# LSC Responses to TIS Redline Comments - SET 2

## Sterling Ranch East Filing Nos. 1 and 1A Traffic Technical Memorandum (LSC #S224570) November 28, 2022

SF-22-035

Figure 2
Site Plan

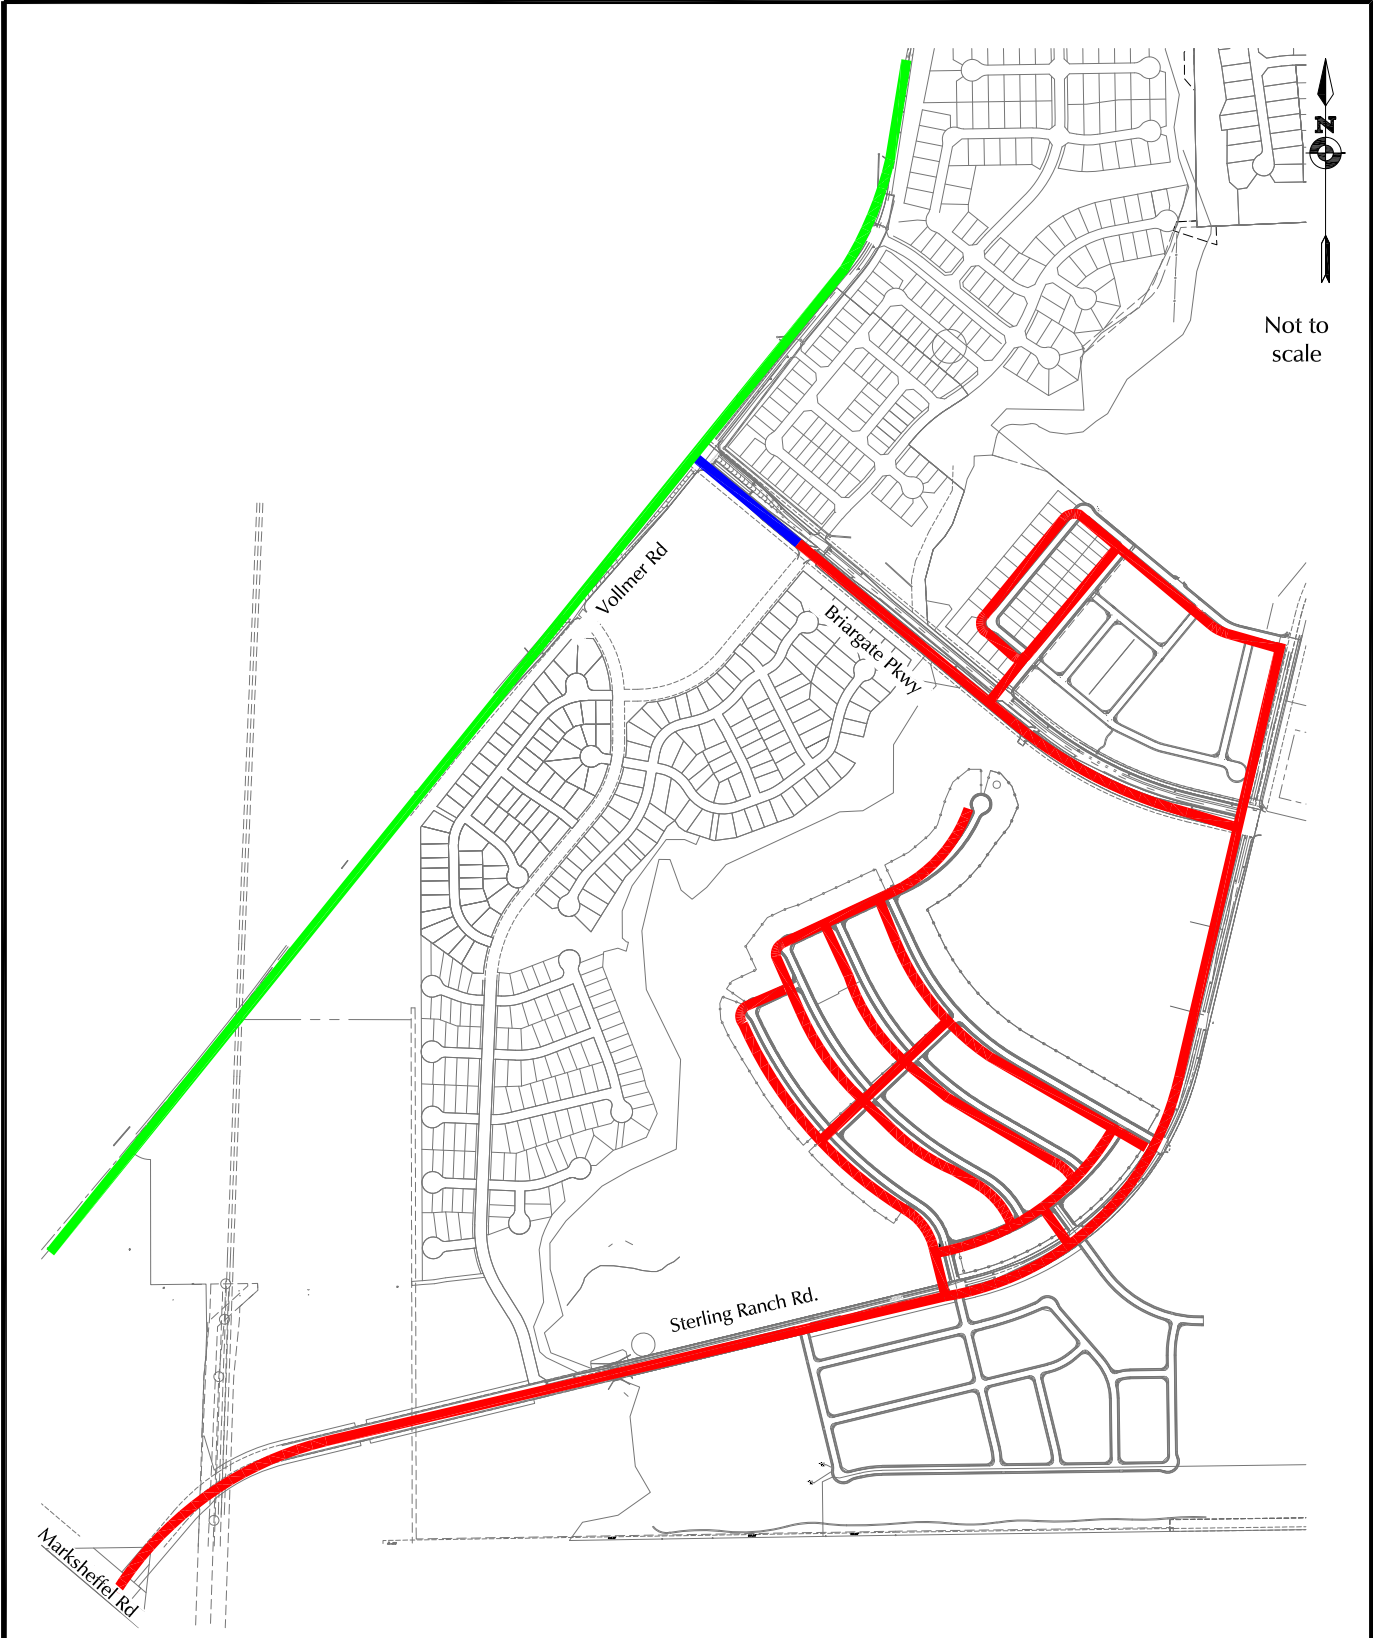
[Label Dines](#)

[Indicate that this is a future access location](#)

↶ Author: kdferrin Subject: Sticky Note Date: 2/10/2023 4:59:02 PM  
LSC Response: Revised as requested.

↶ Author: kdferrin Subject: Sticky Note Date: 2/10/2023 4:58:55 PM  
LSC Response: Revised as requested.

Figure 4a

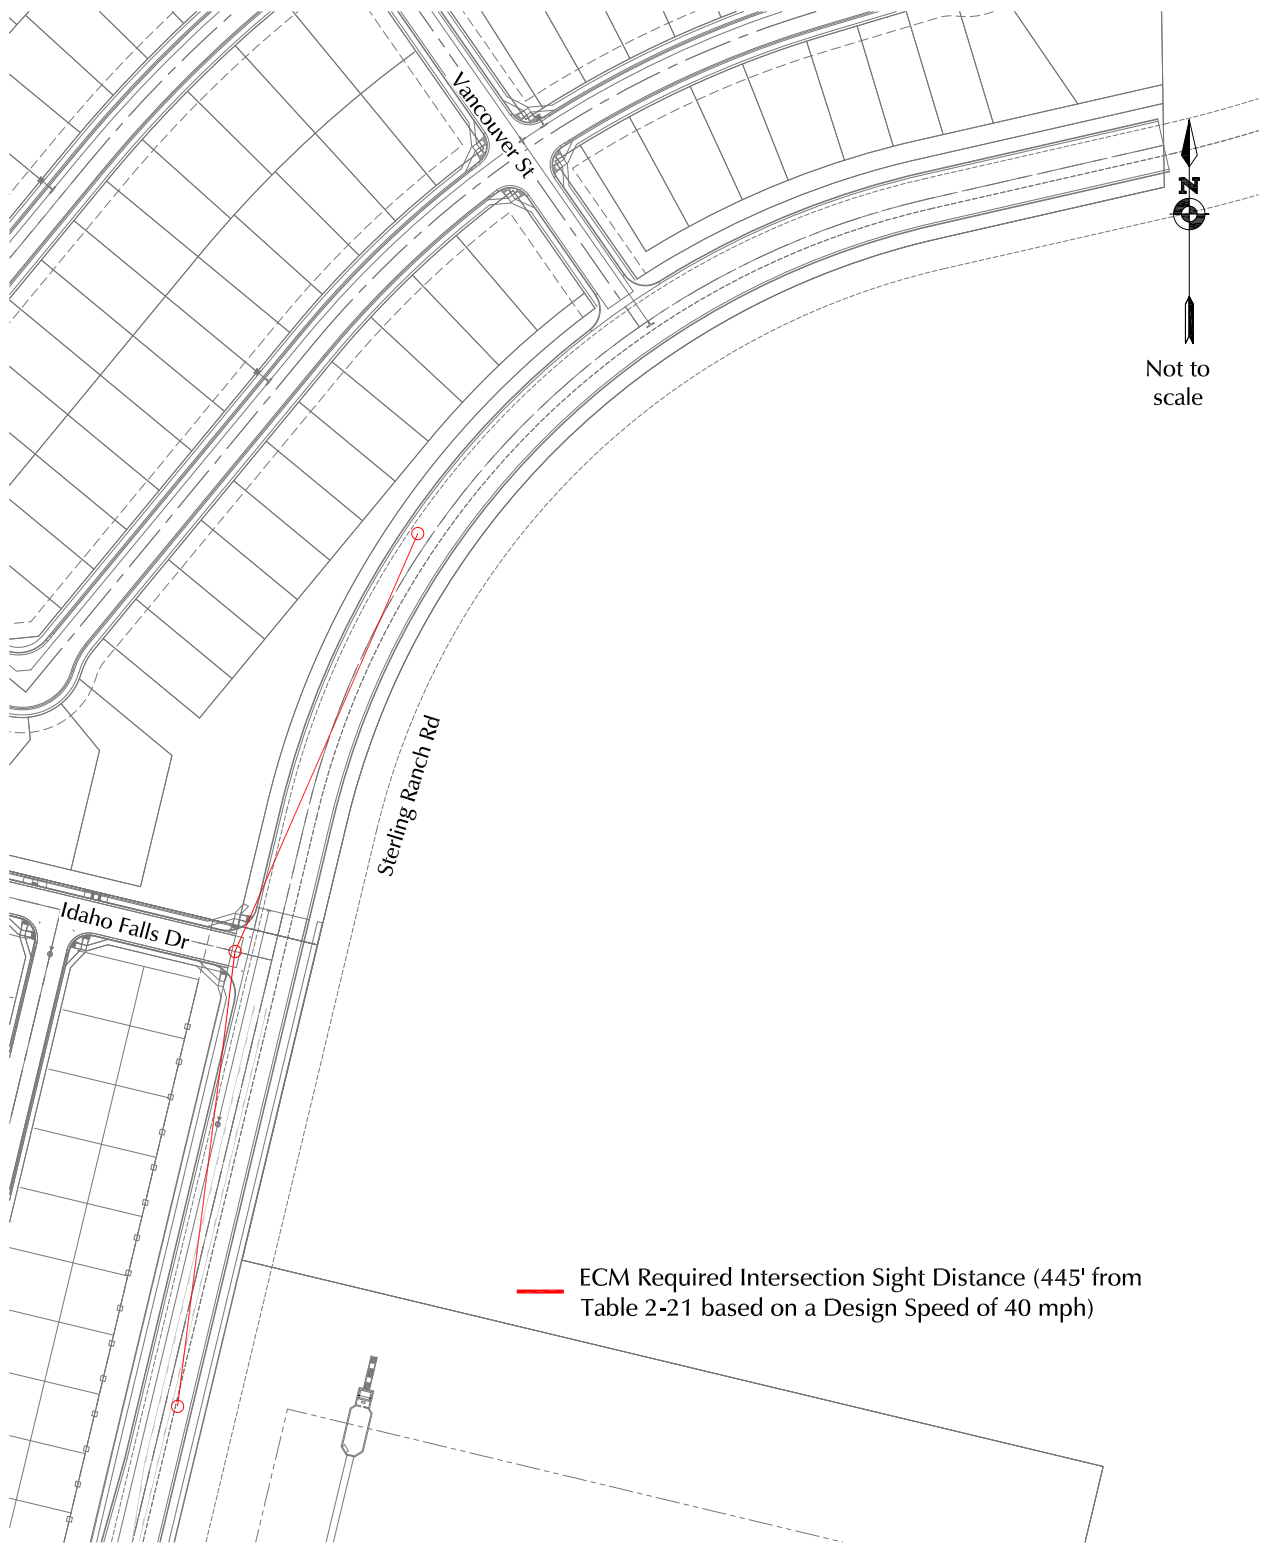
Number: 2 Author: CDurham Subject: Callout Date: 1/9/2023 12:58:30 PM  
555'

Author: kdferrin Subject: Sticky Note Date: 2/10/2023 2:34:34 PM  
LSC Response: Revised as requested.
